26 November 2024

Ref No: F2024/00464

RE: SSD 71454960 - Redevelopment at 195-213 Fitzgerald Avenue and 40-64 Yorktown Parade, Maroubra by Homes NSW

Randwick City Council submits this interim response to the Department of Planning, Housing and Infrastructure regarding the lodged State Significant Development application for the redevelopment at 195-213 Fitzgerald Avenue and 40-64 Yorktown Parade, Maroubra by Homes NSW.

NOTE:  
 TOTAL SITE CANOPY COVER AT MATURITY=3354.15M2 = 34.77%  
 IF INCLUDE OPTION B ADDITIONAL STREET TREES(7 STREET TREES WITH CANOPY COVER OF 269.25M2 IN TOTAL) FOR YORKTOWN PARADE

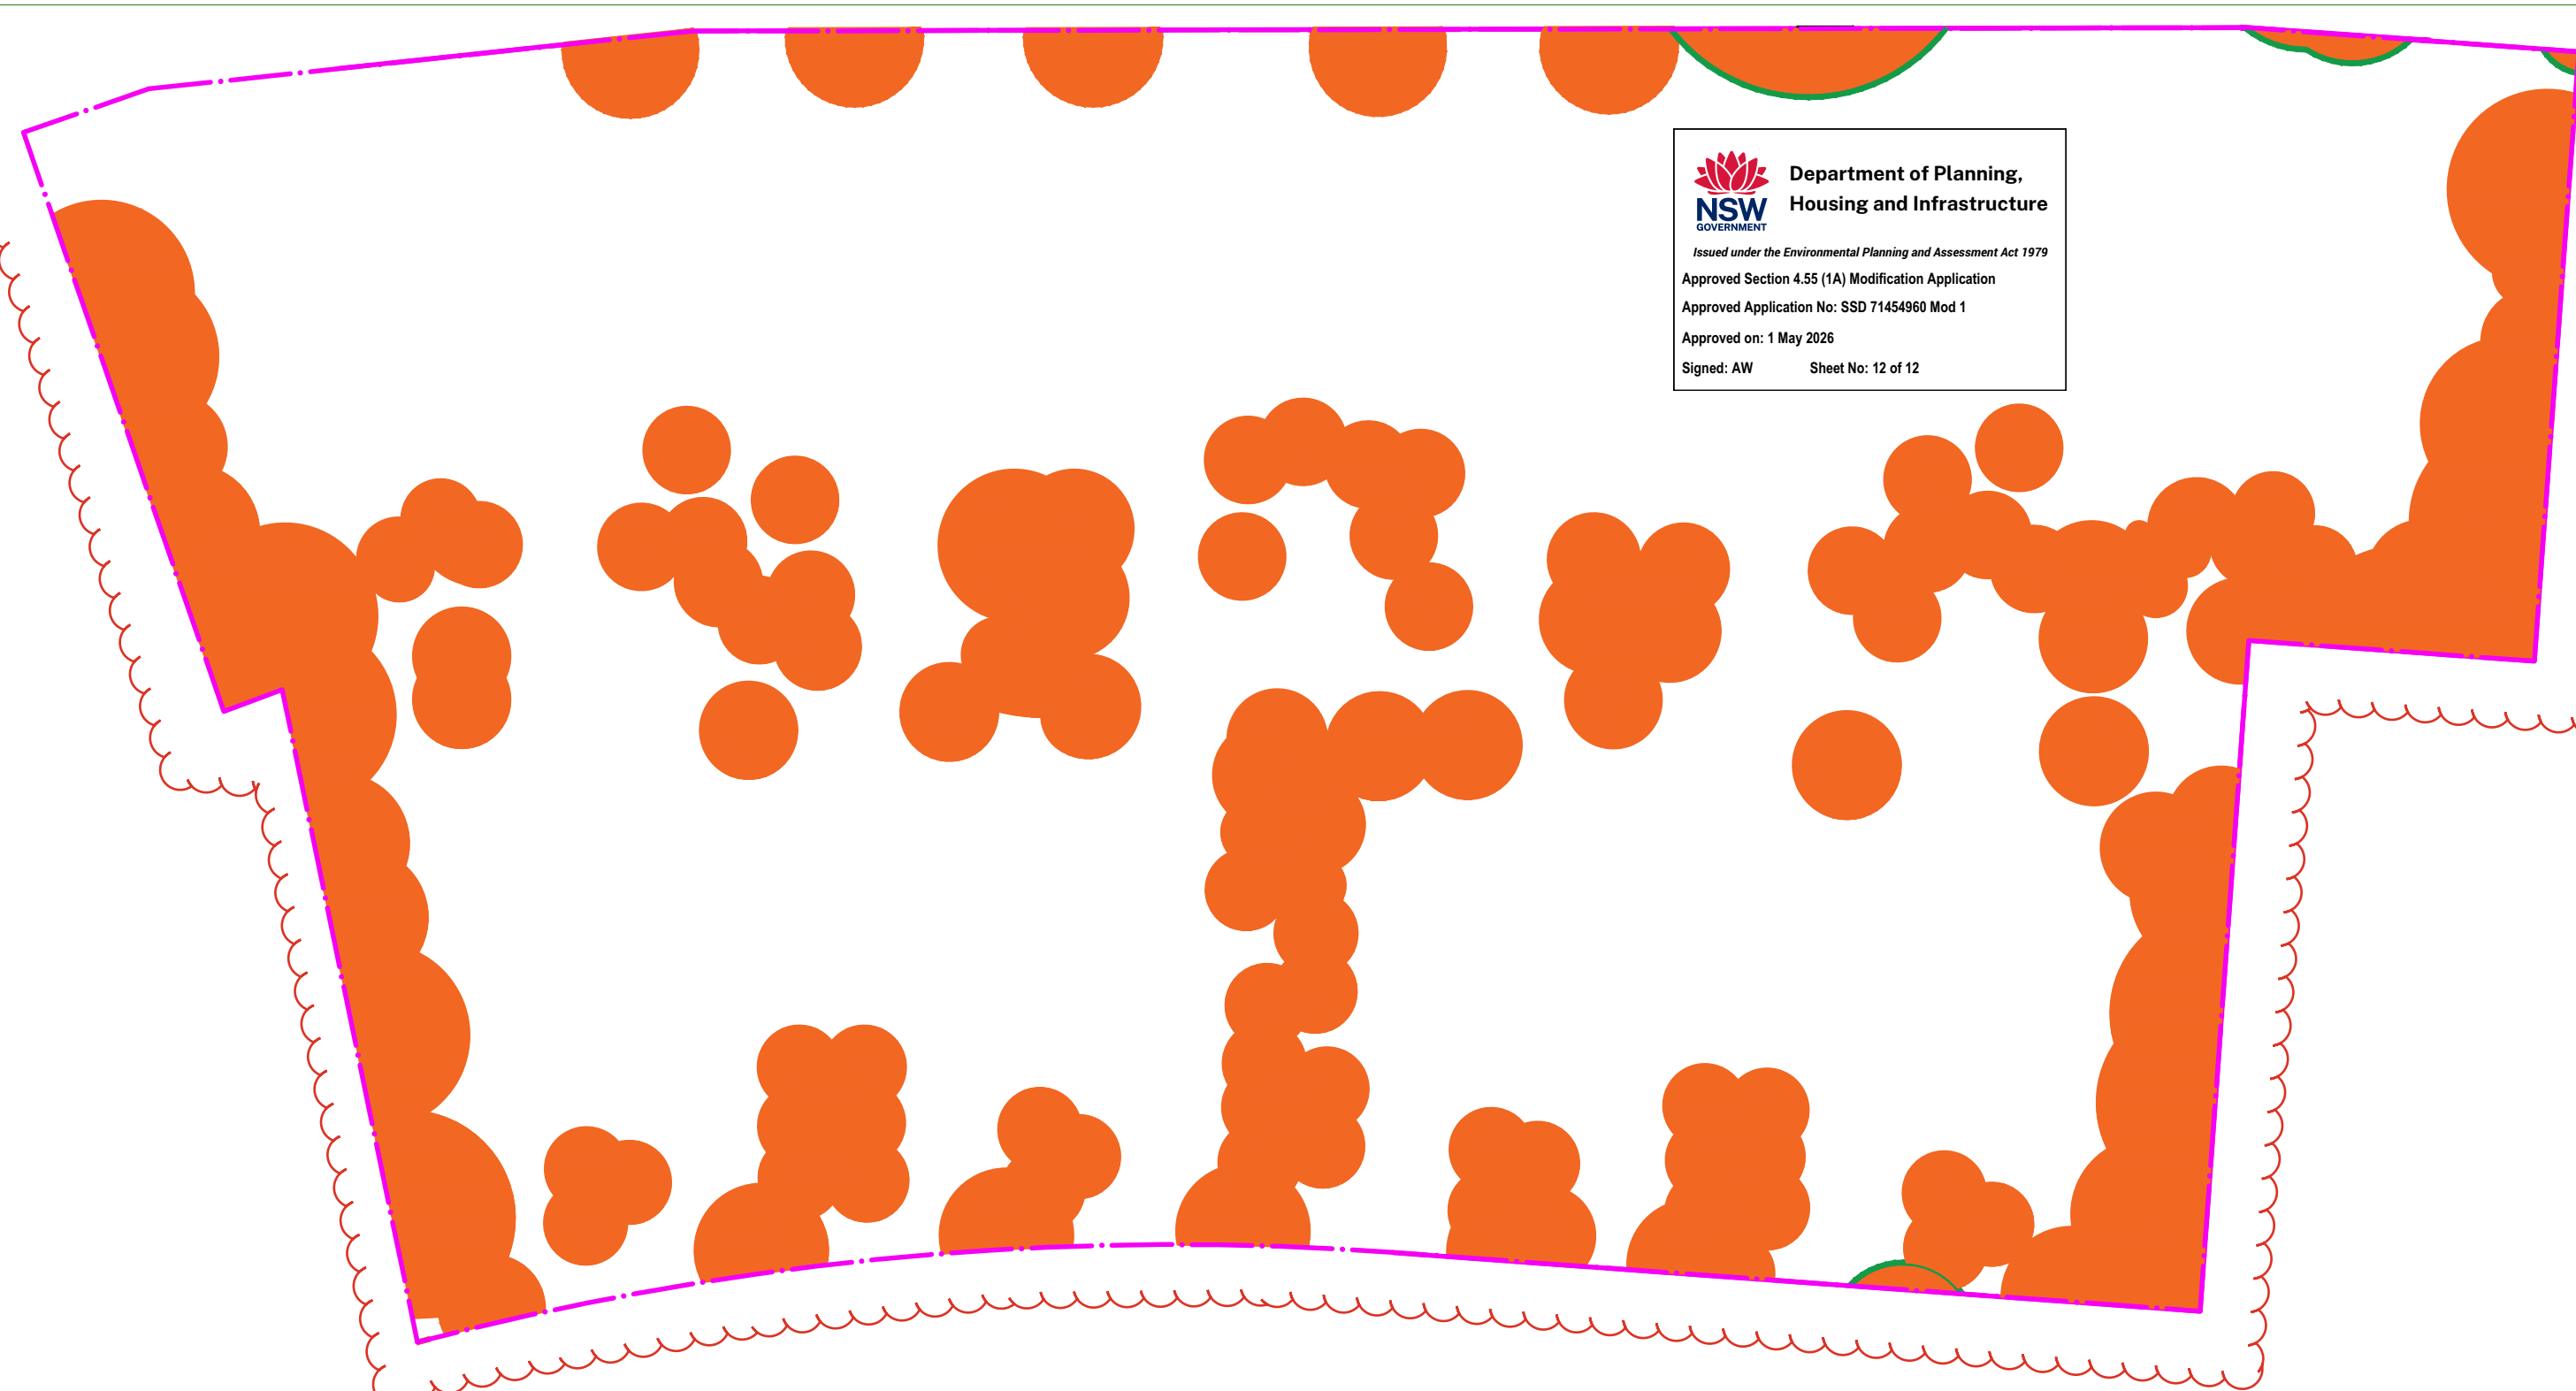
Council is supportive of the high level of street tree retention on both Fitzgerald Avenue and Yorktown Parade and along with the substantial deep soil and landscaping areas proposed. Regarding canopy cover, as shown in the application documentation, the proposal at 24% does fall short of the 30% target contained within the DPHI greener places guidance.

Given substantial reduction in vehicle crossovers to Fitzgerald Avenue and Yorktown Parade and the associated increase in potential landscape / planting area, it is recommended that new street tree planting be incorporated into the proposal to assist with offsetting any reduced canopy cover that can be achieved within the subject site.

As several large tree species are located within the Fitzgerald Avenue verge, appropriate space should be retained for these species to reach maturity. It is therefore recommended that any proposed street tree planting be directed to Yorktown Parade.
